October 15, 2013
13251

Level III Site Plan Application
Seaport Lofts: Submittal No. 6

SUMMARY OF RESPONSES TO NEIL DONALDSON EMAILED COMMENTS DATED OCTOBER 09.

**TYPICAL DRAINAGE MANHOLE/CATCH BASIN**  
NOT TO SCALE

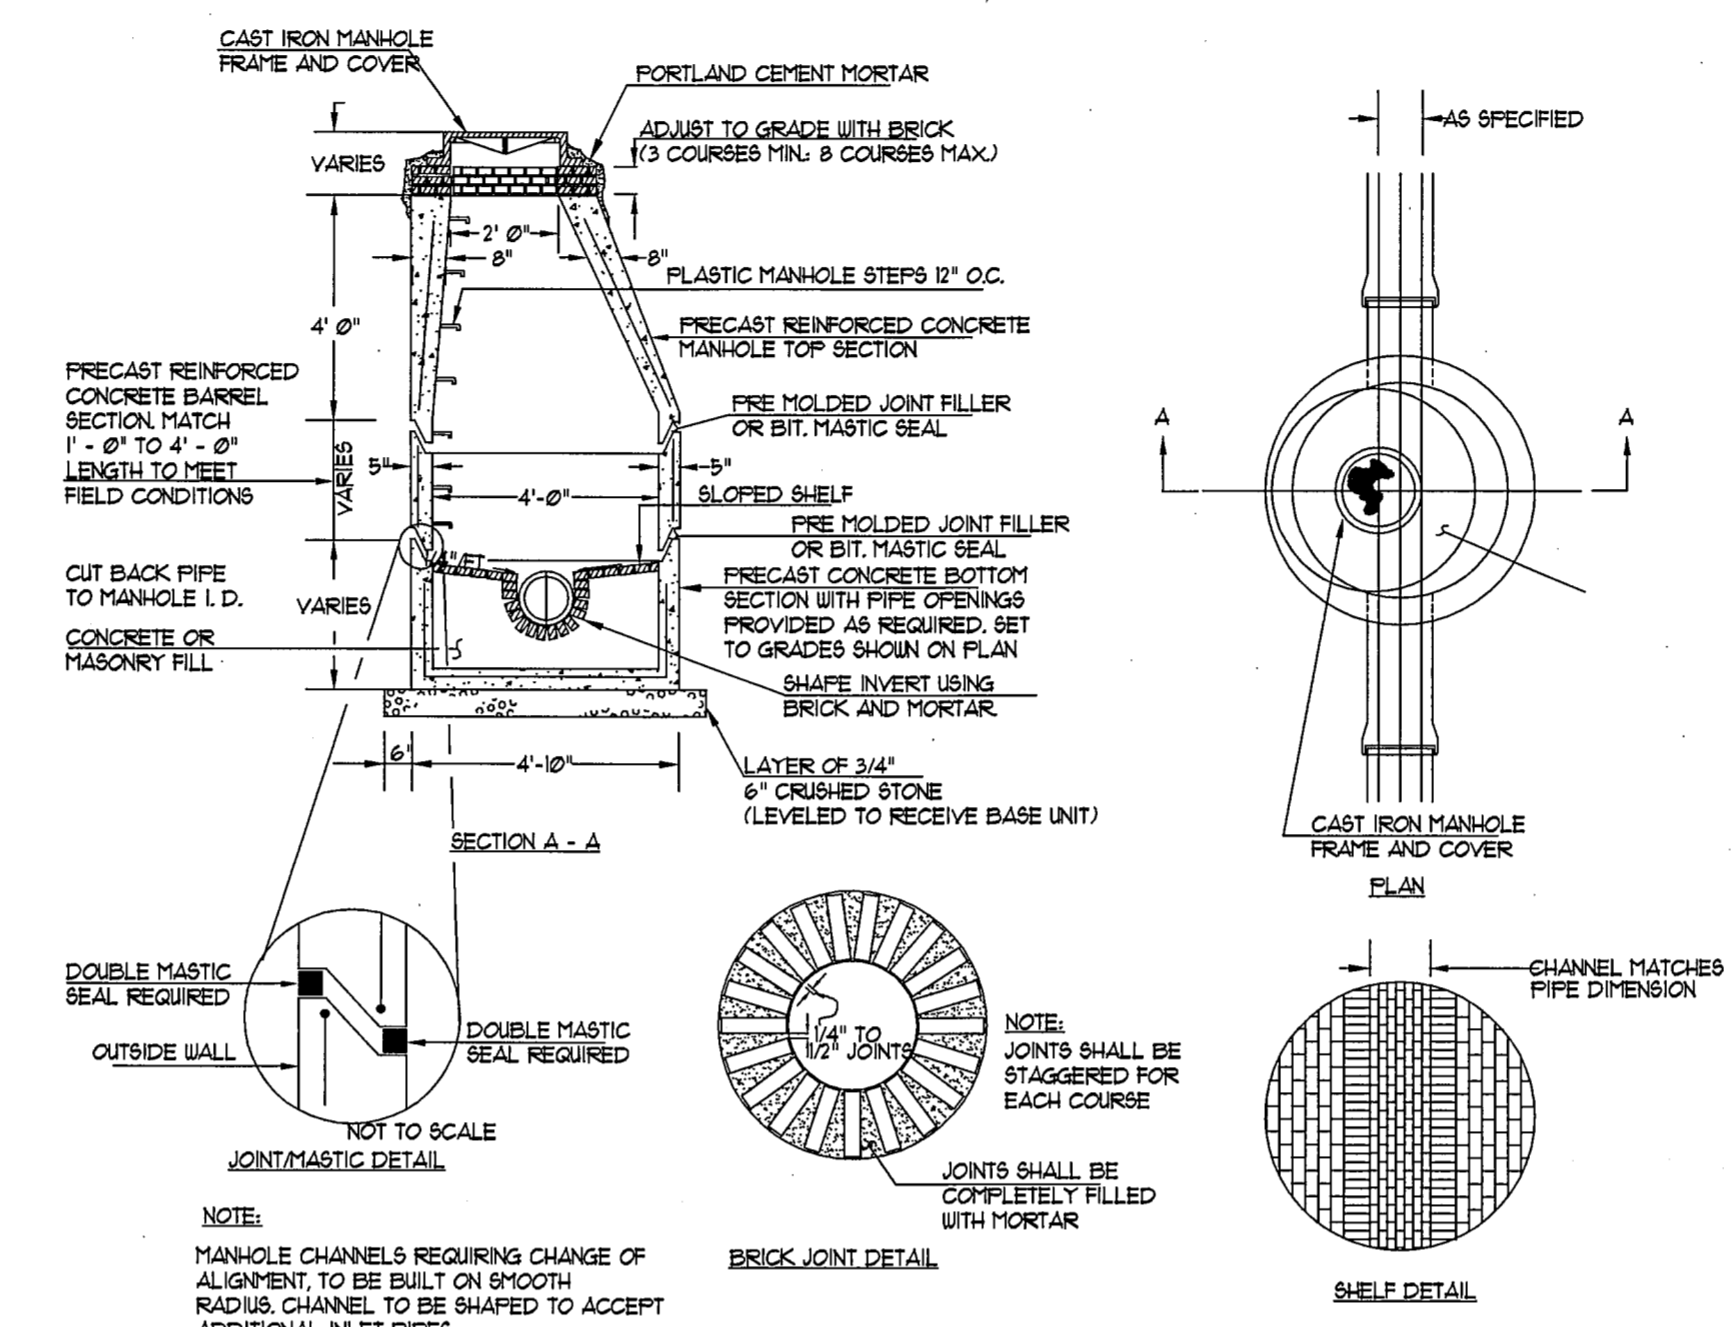
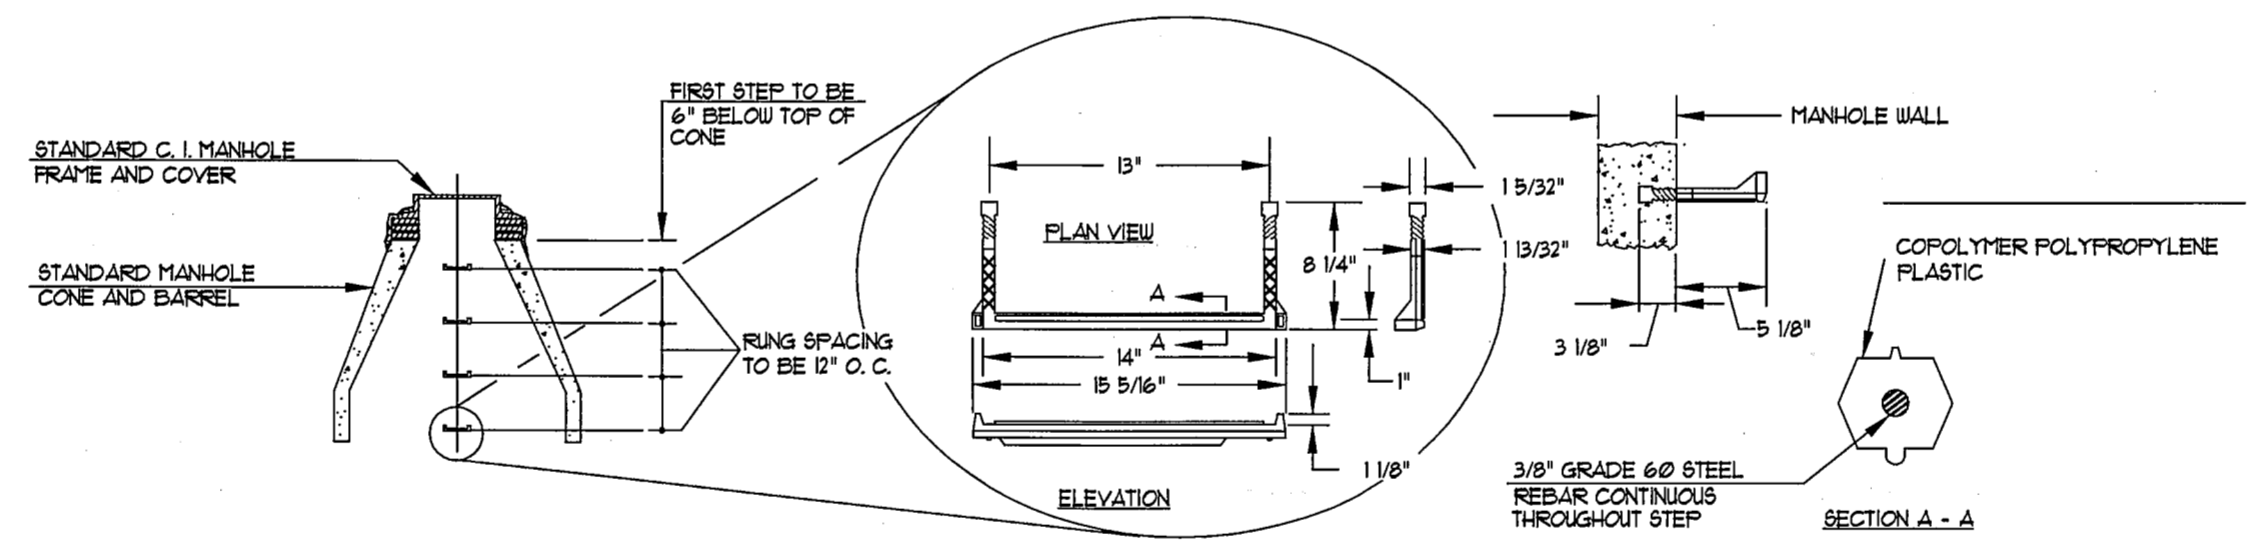
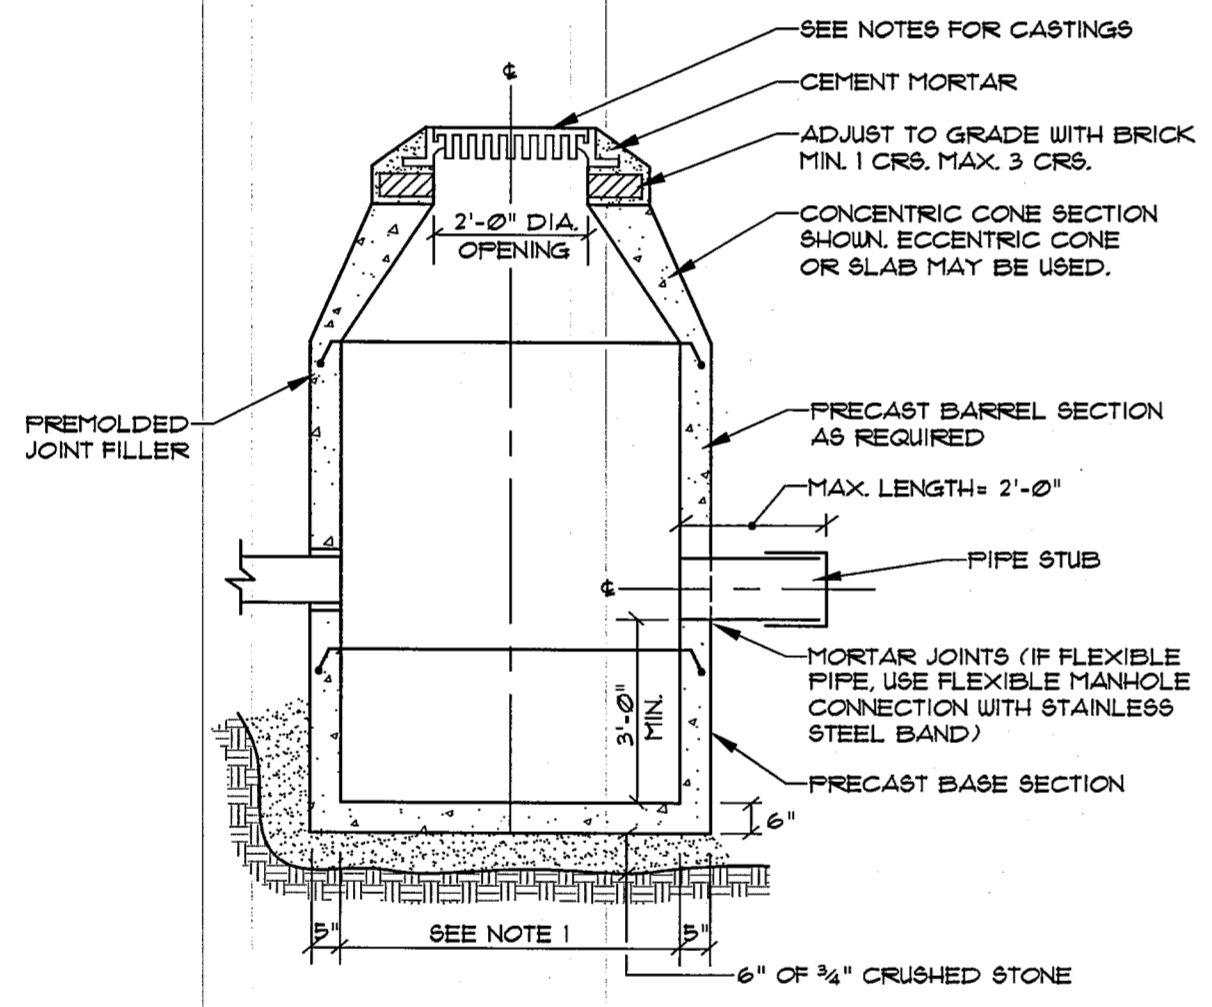
- 5.3). The catch basin sump is now shown as 3' and the notes pertaining to the drain manholes have been added, as requested.
 - 5.4). We removed the extraneous text near Line L1 on the Subdivision Plat.

**SHEET 4 OF 14**

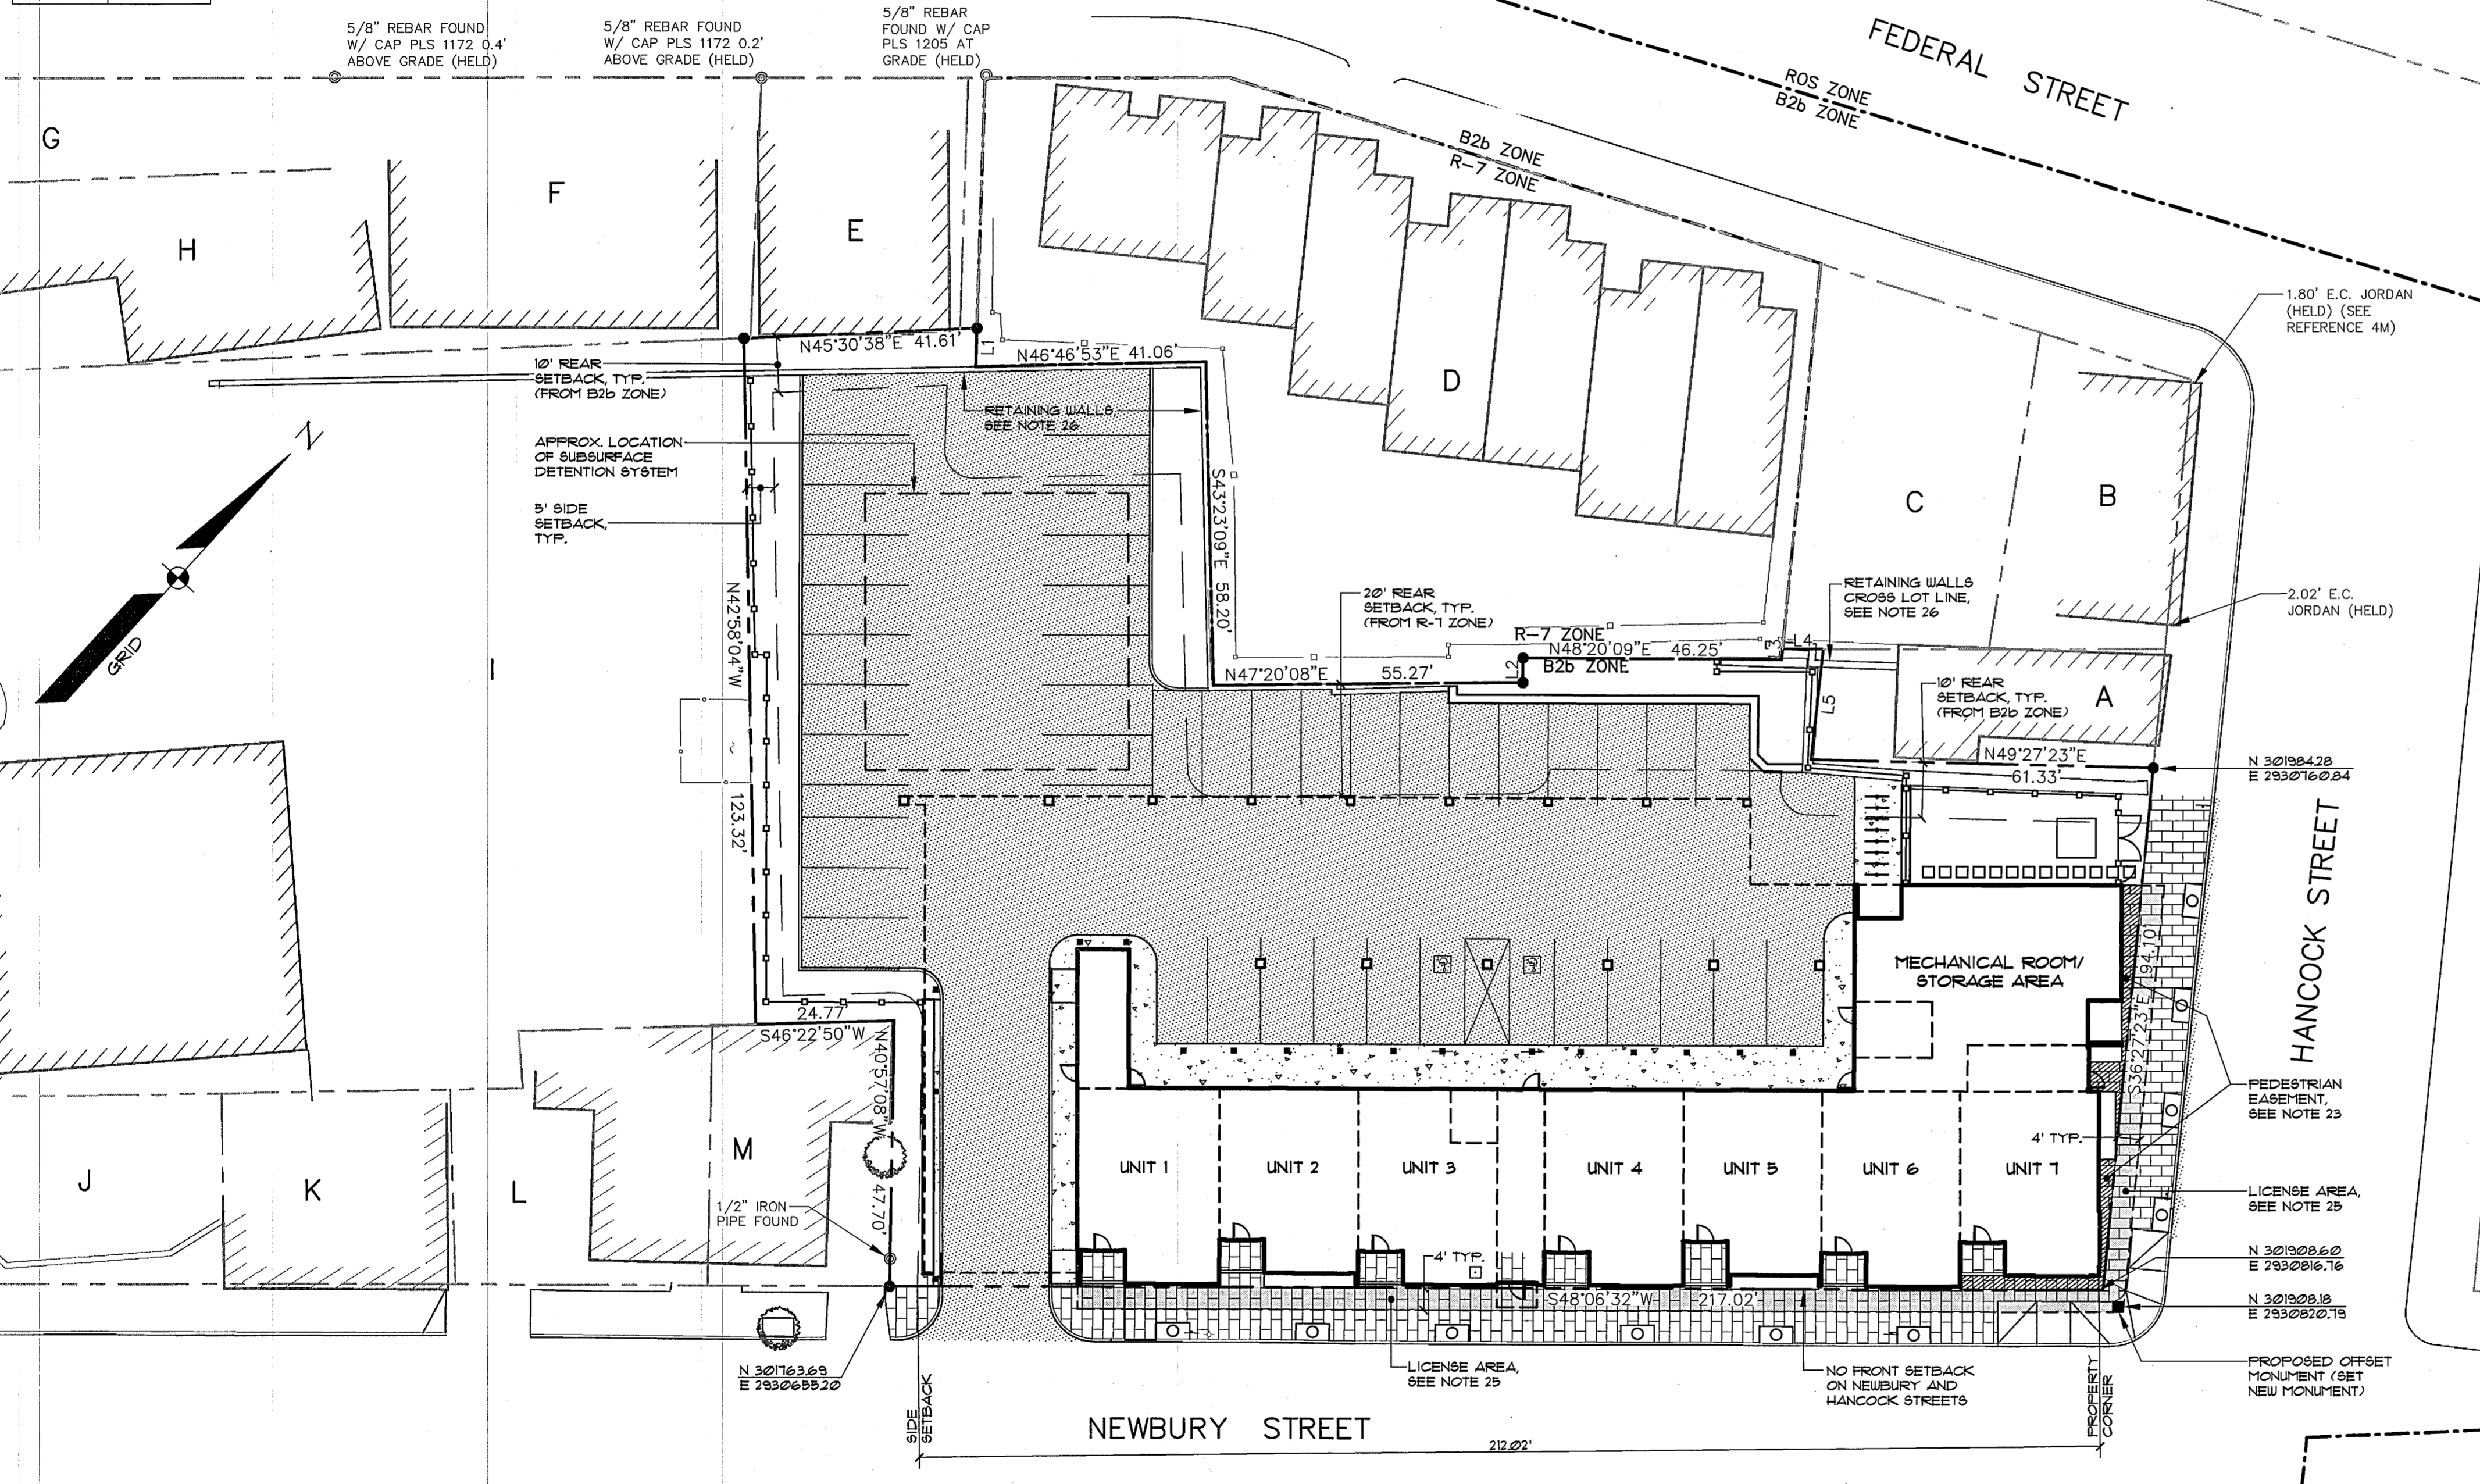
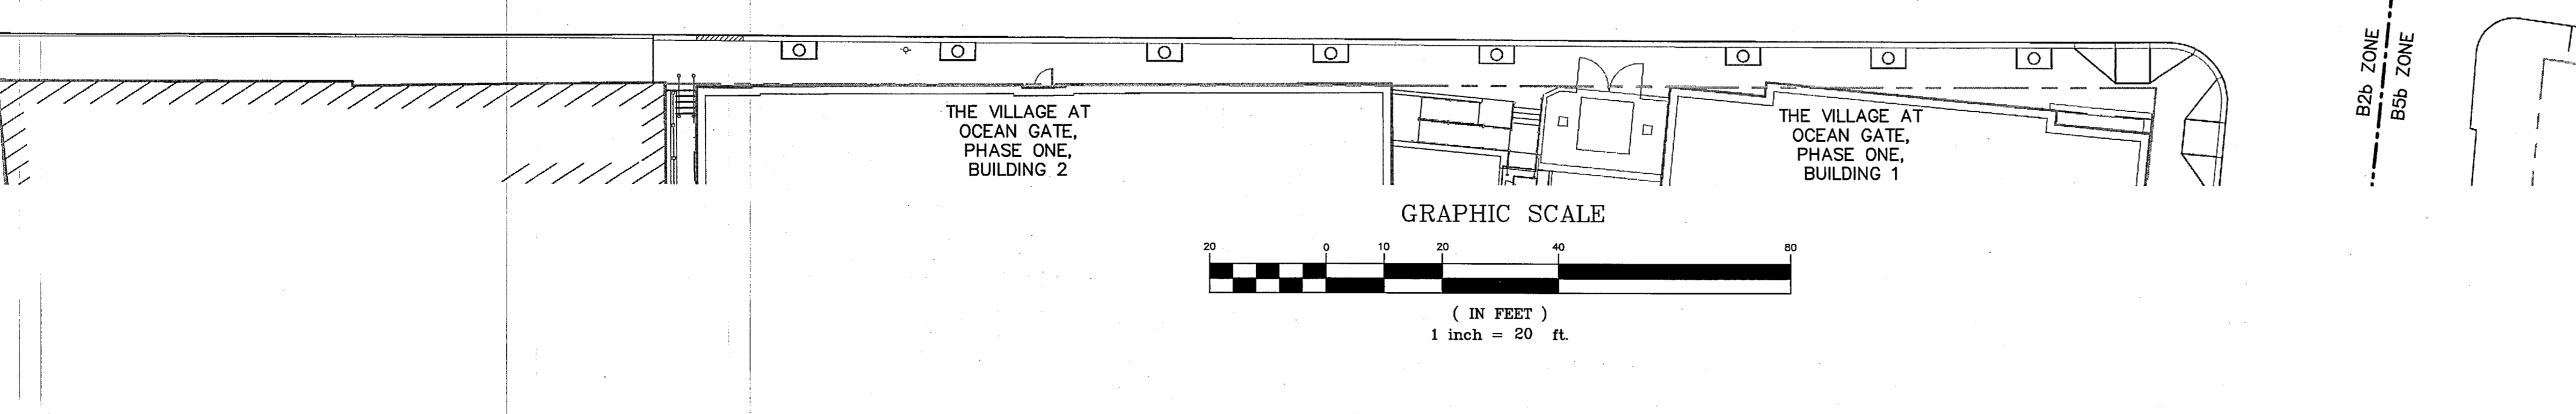
1. We understand that David Senus and Marge Schmuckl are satisfied with prior responses and have no further comments.
- 2a). The site drawings have been updated to reflect changes to the building footprint and canopies.
- 2b). We added a note on the Site Plan that the townhouse entries will be illuminated "with details to be provided to the City per conditions of approval".
- 2c). We have selected a more contemporary, less ornate wall mounting bracket for light fixtures – see Revised Attachment T- Lighting Cut Sheets.
- 2d). Note # 23 on the Subdivision Plat has been revised as requested.
- 2e). The stormtech/ subsurface detention system has been added to the Subdivision Plat as requested.

- 5.1). We added a note on the Subdivision Plat regarding the responsibility of maintaining the retaining walls, as requested.
 - 5.2). The invert elevations of the pipes noted have been revised as requested.

- 5.5). We added a note to the Subdivision Plat regarding the ownership of retaining walls at the northwest corner of the site, as requested.
- 6). We revised the note regarding the street monument as requested.

- 7). We enlarged the text boxes on the Subdivision Plat as requested.
